April 7, 2022

**Re: Raising Cane's 4800 Montgomery Blvd. NE  
Erosion and Sediment Control Plan  
Engineer's Stamp Date 4/4/2022 (G17E011)**

EROSION CONTROL PLAN PH. I

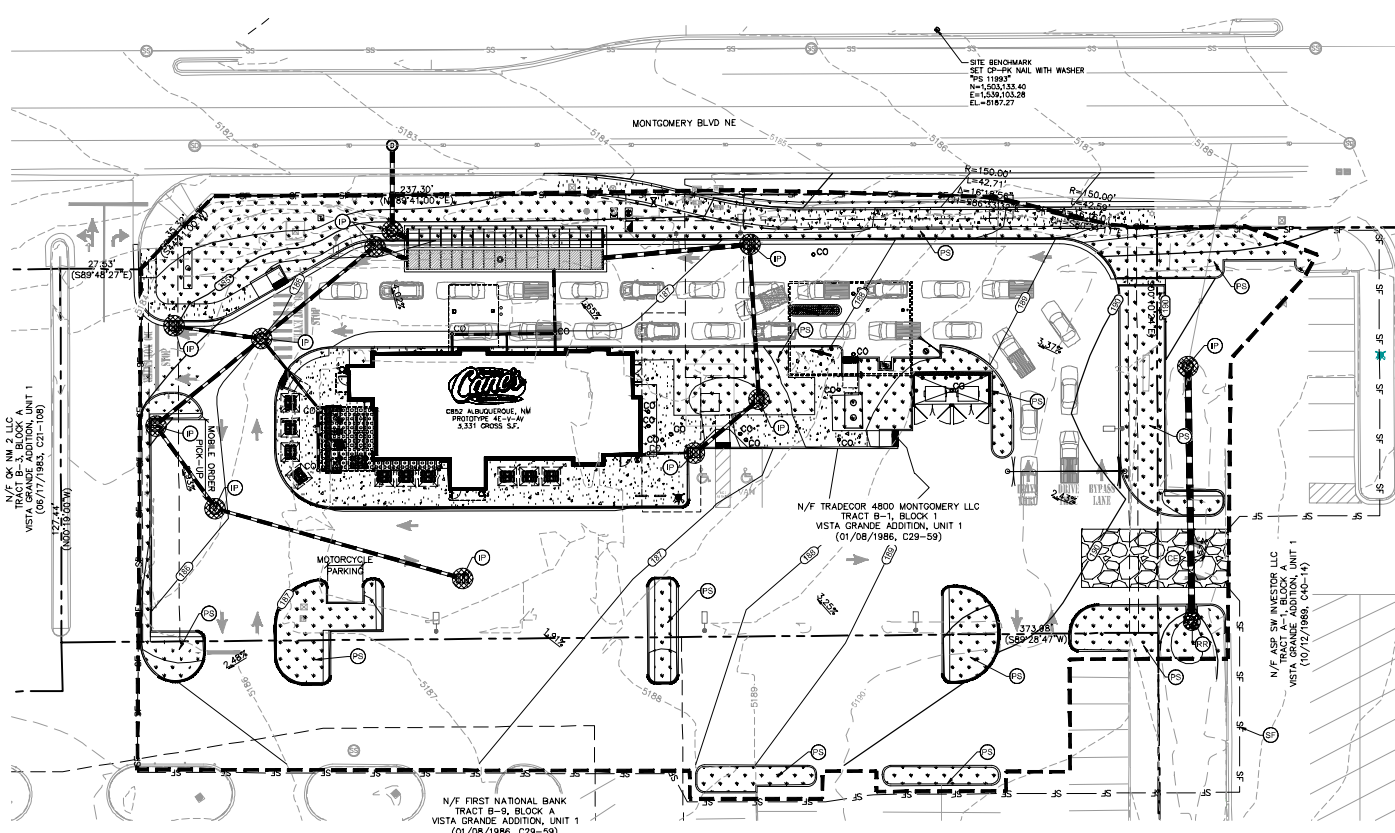
1. The ESC Plan can't be approved until after Hydrology approves the G&D Plan. The existing and proposed grades and storm drains must be shown on the ESC Plan, and they must agree with the Grading Plan approved by Hydrology (CGP7.2.4.b.ii);
